Planning Application Reference No.: 3/2021/0275

Address of Development: Land behind The Dog Inn, Market Place, Longridge PR3 3RR

11th November 2022

Ref. Planning Application No: 3/2021/0275

Site Section through The Dog Inn, Plot 2 and 36 Darwen Close

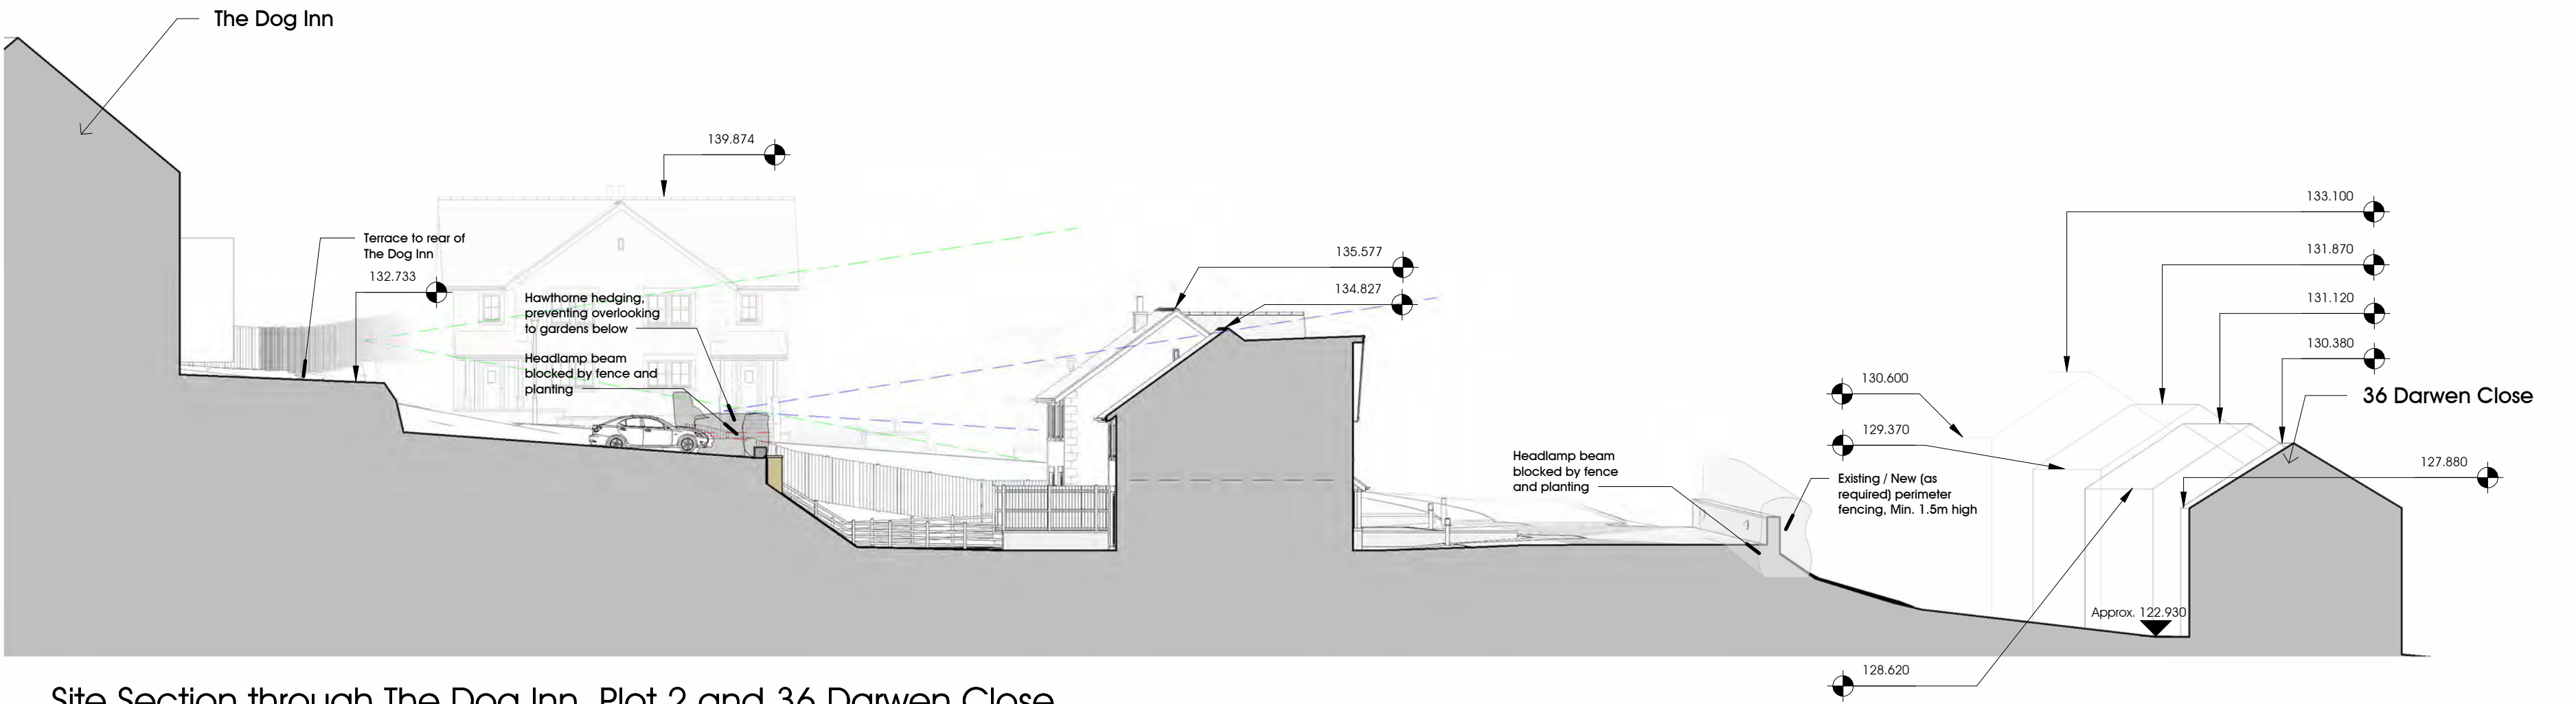
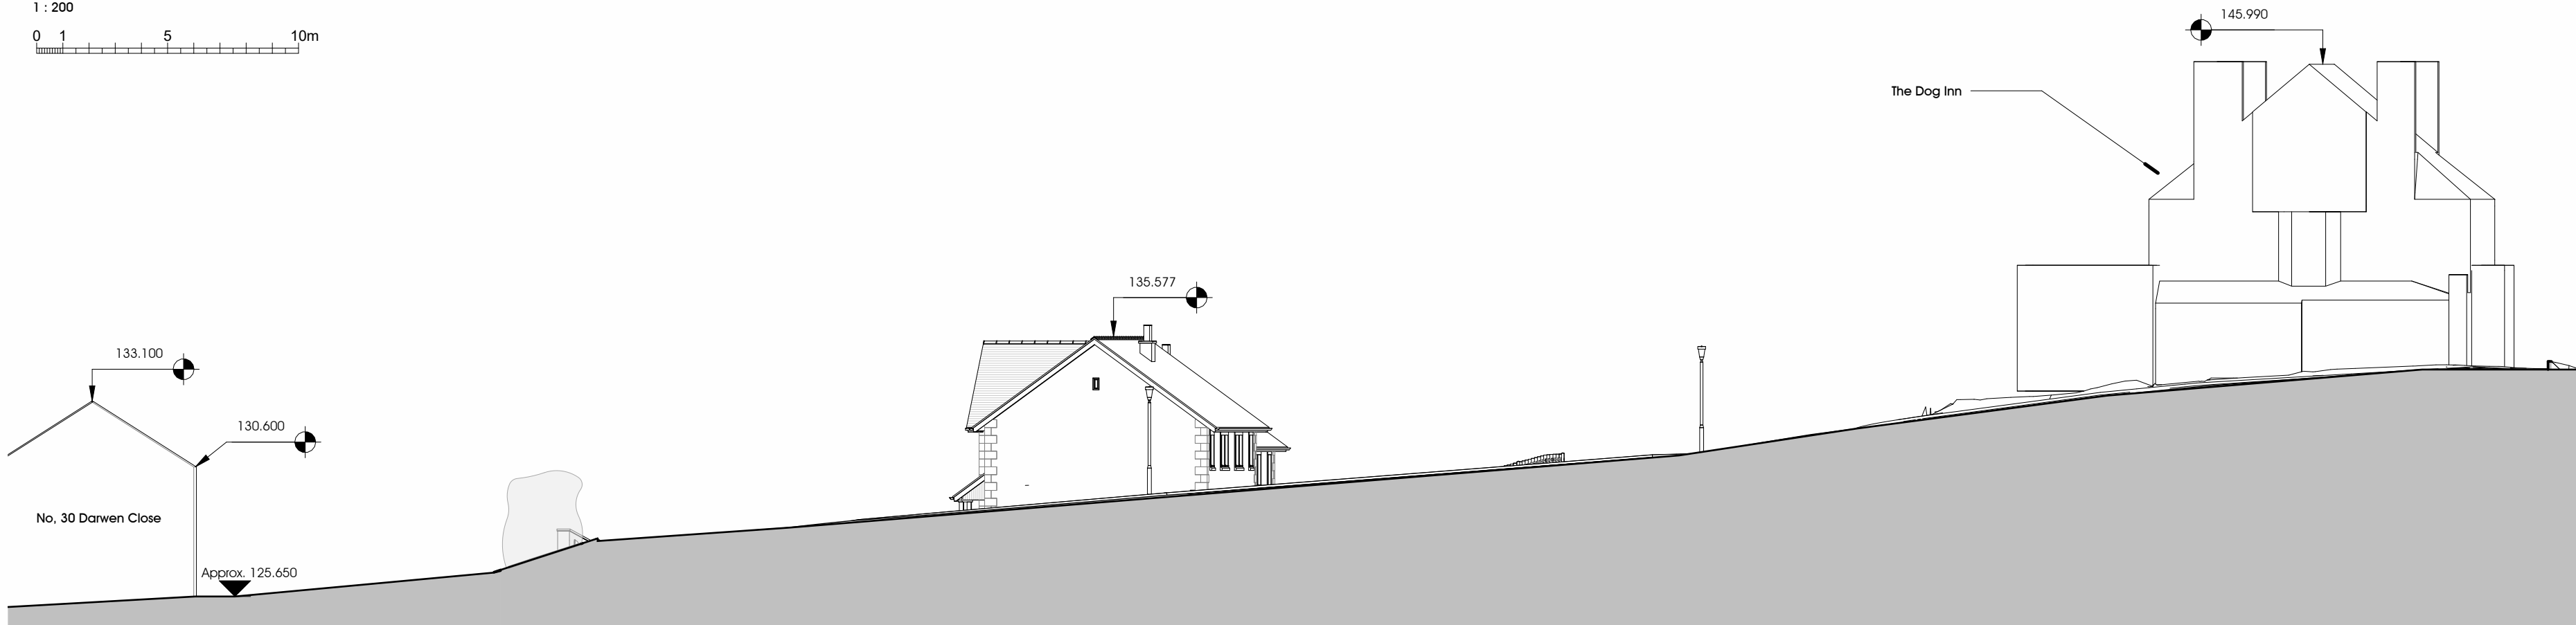
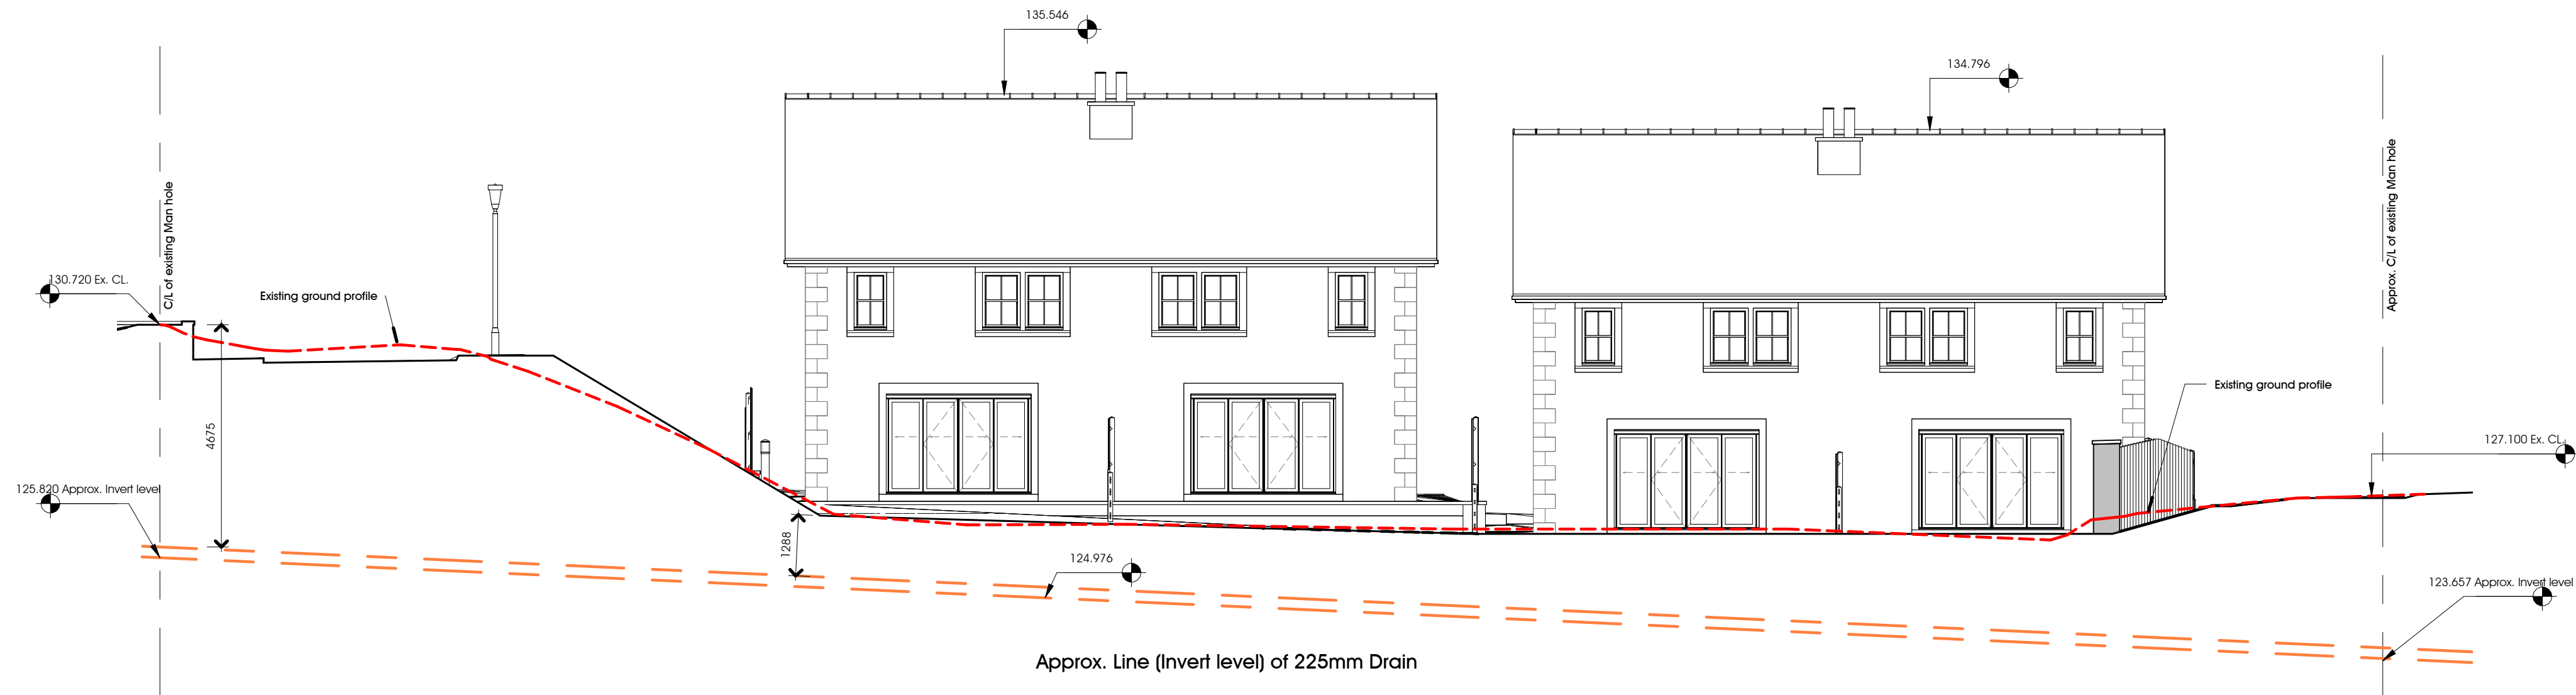
1. Viewing the plans from the properties on Darwen Close, they show that the proposed development will be imposing to the extreme, due to the height difference of the land. This has always been a concern and with the latest plans there is an increase in the height on the proposed plots 5 to 8, with plot 6 being 0.9m higher than the former plot 4. [REDACTED]

2. The first floor windows in the proposed plot 5 and 6 are significantly [REDACTED]. The height differential is approximately 4m higher than [REDACTED]
